Application No: LU/210/21/HH
Site Address: The Flint House 11 Irvine Road Littlehampton BN17 5LB
Description of works: Remove existing rear conservatory and construct new kitchen extension and extension to annex living room. Internal alterations to improve the layout. This application may affect the character and appearance of the Littlehampton Sea Front Conservation Area.

Thank you for your internet representation made on 1st August 2021 which has been recorded as an objection with the comments as follows:

OWPC39062

Drawing
Location, Site, proposed floor plans and elevations

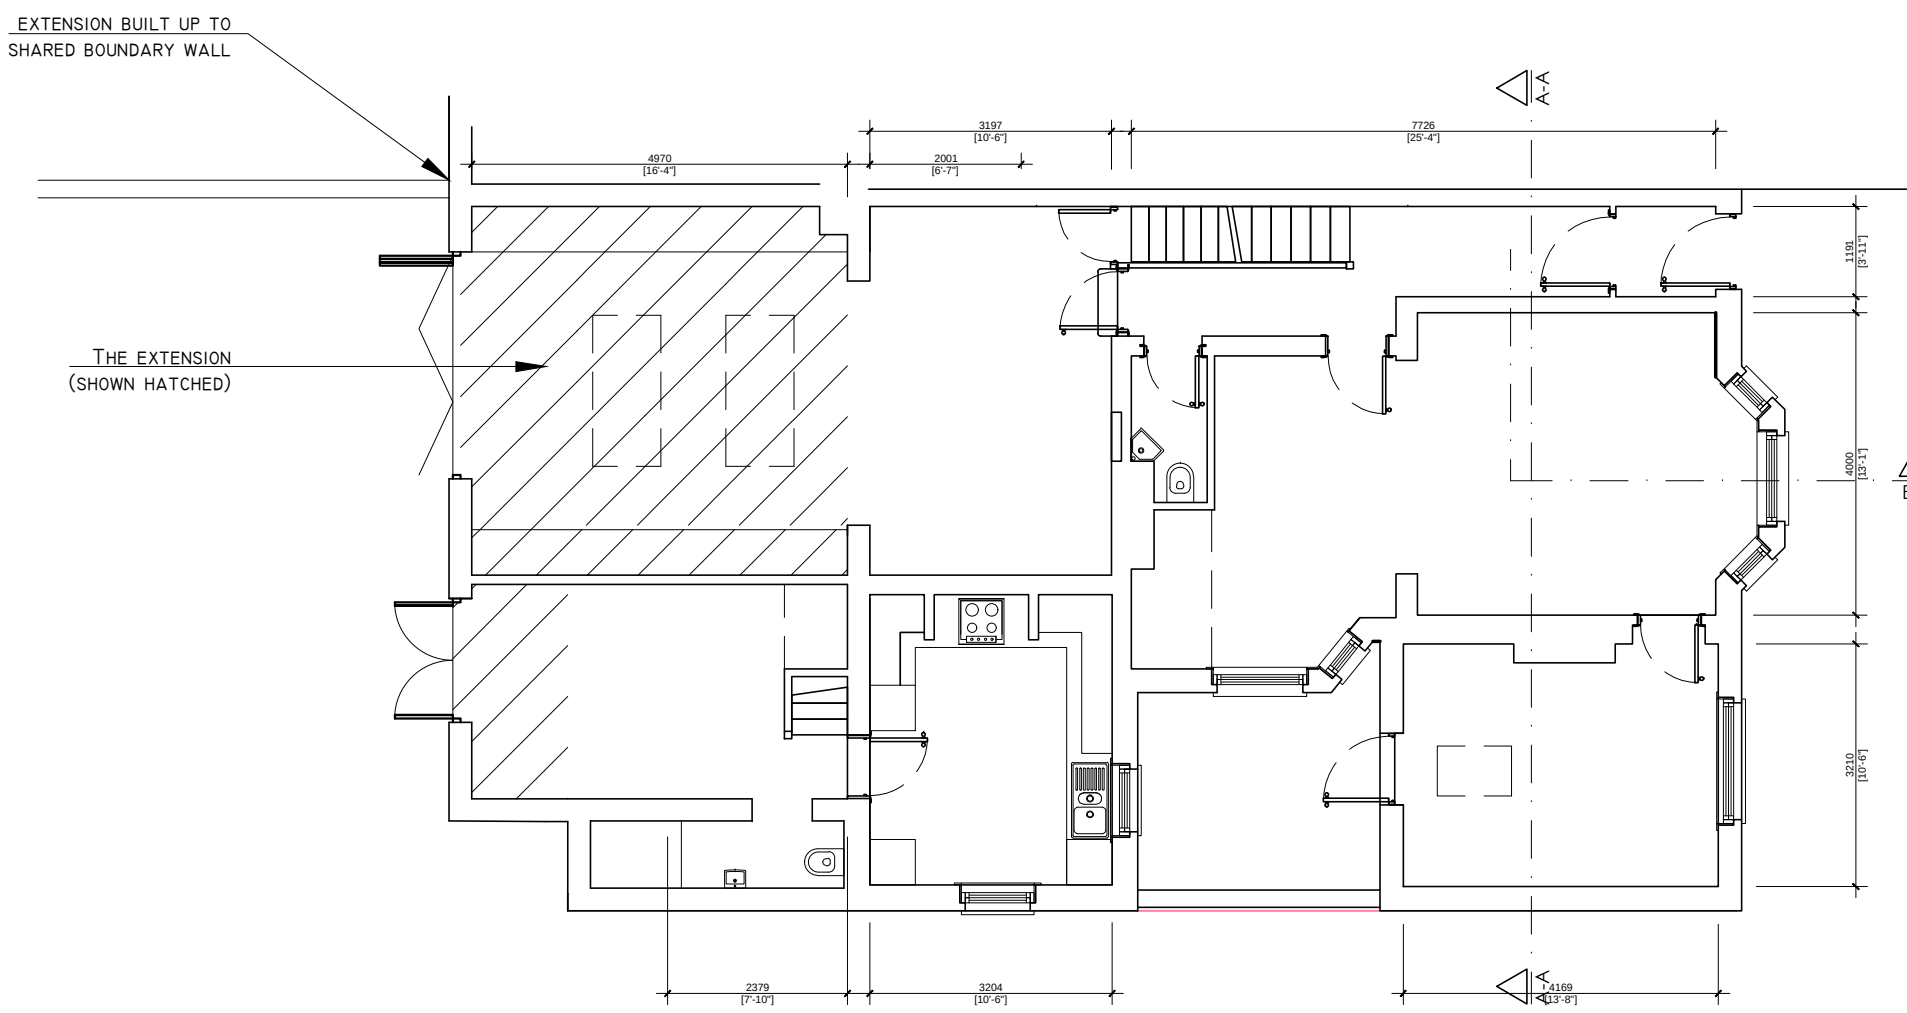
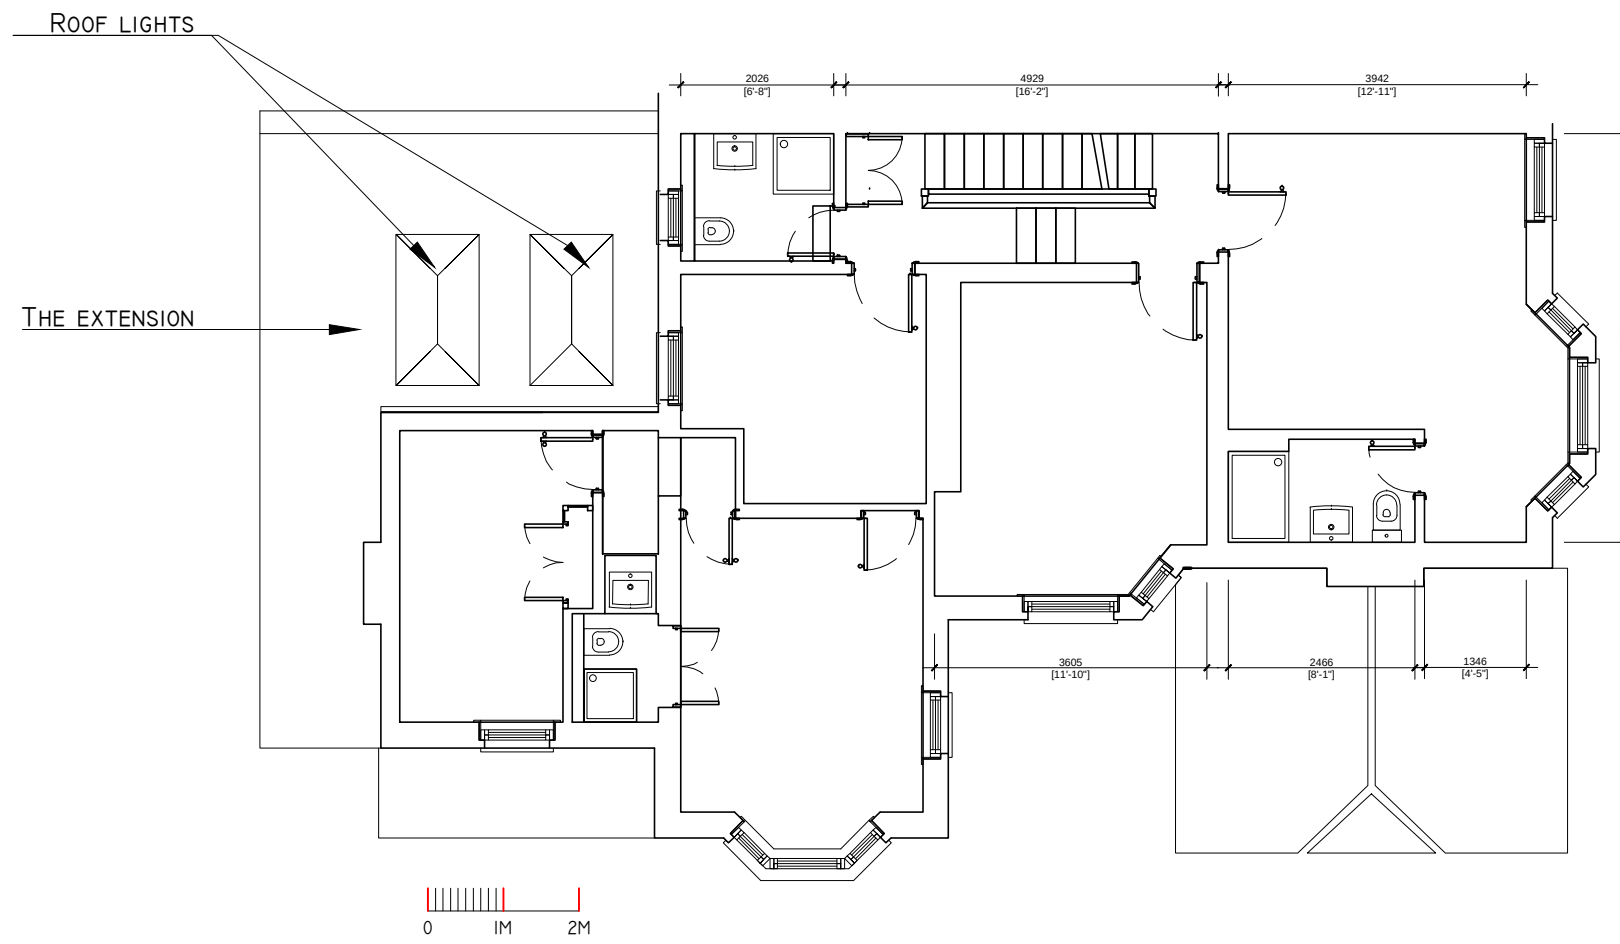
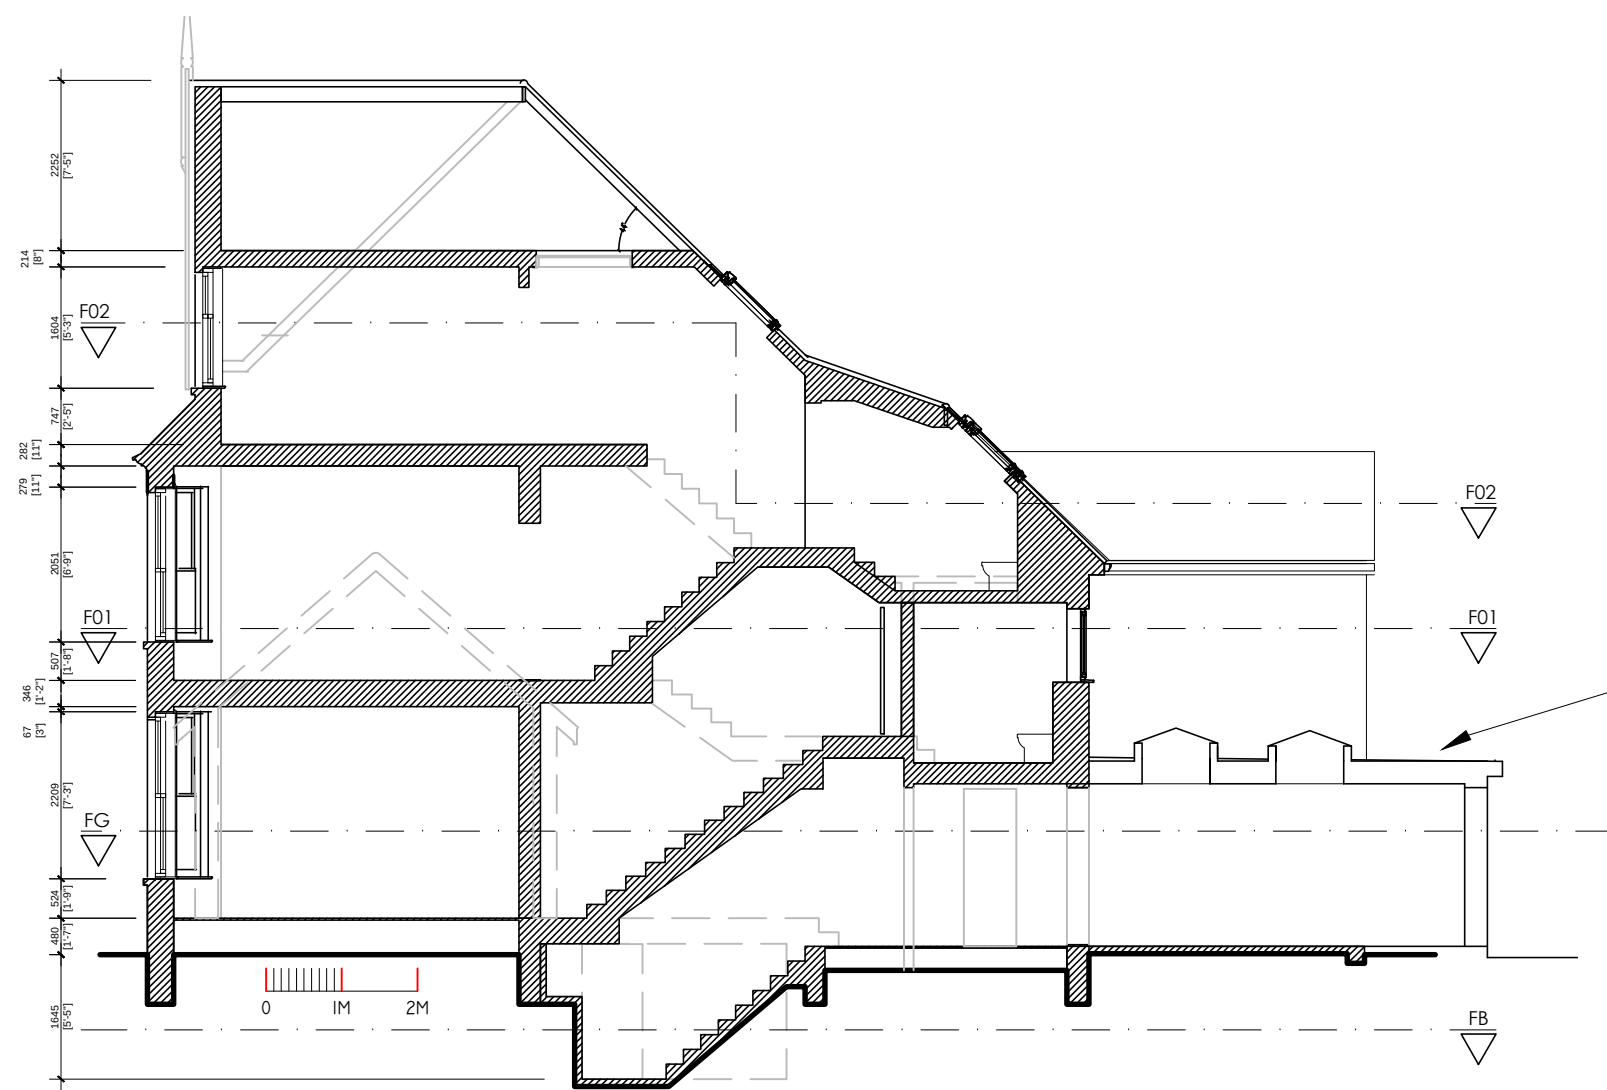
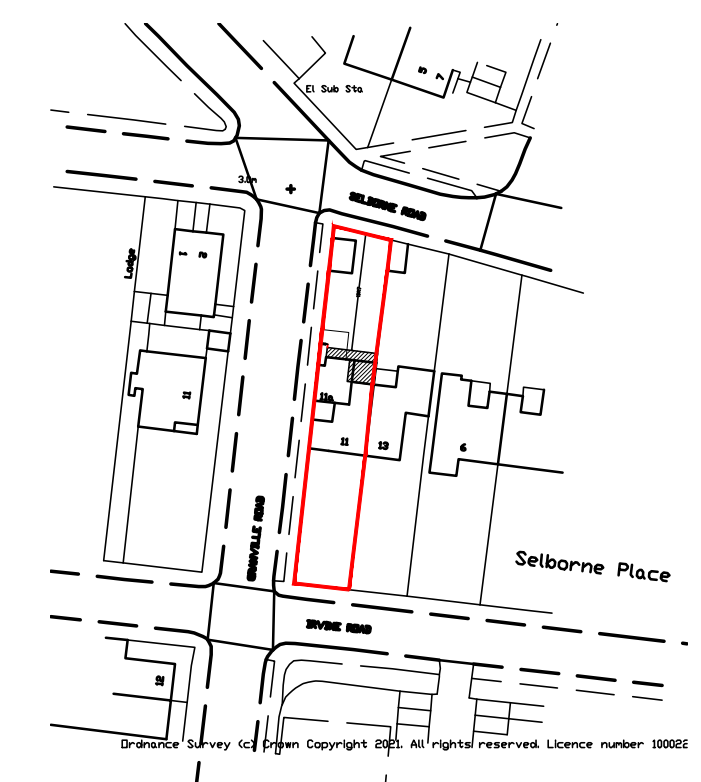
The upper part of the proposed flat roofed extension is likely to be visible in the Granville Road streetscene. The Panel see no objections to the principle of an extension although, if possible, a design solution using slate pitched roofing would have been preferred. The choice of brick and its bond will be important. However, the main concern is that there is no detailed drawing showing how the junction between the external walls and the flat roof will be treated. From the drawings submitted the proposed detail could well result in a deep, plain, fascia board which will appear crude and incongruous in relation to the historic building and the street scene. Given the heritage asset context a sensitive and appropriate detail is needed which could include, for instance, moulded exterior cornicing or low parapets with stone copings.

In the absence of such satisfactory detailed drawings then it is considered that there is the potential for the proposal to detract from the appearance of the building and the conservation area, in conflict with the relevant paragraphs of the NPPF and policies contained in the ADLP relating to the protection of non-designated and designated heritage assets.
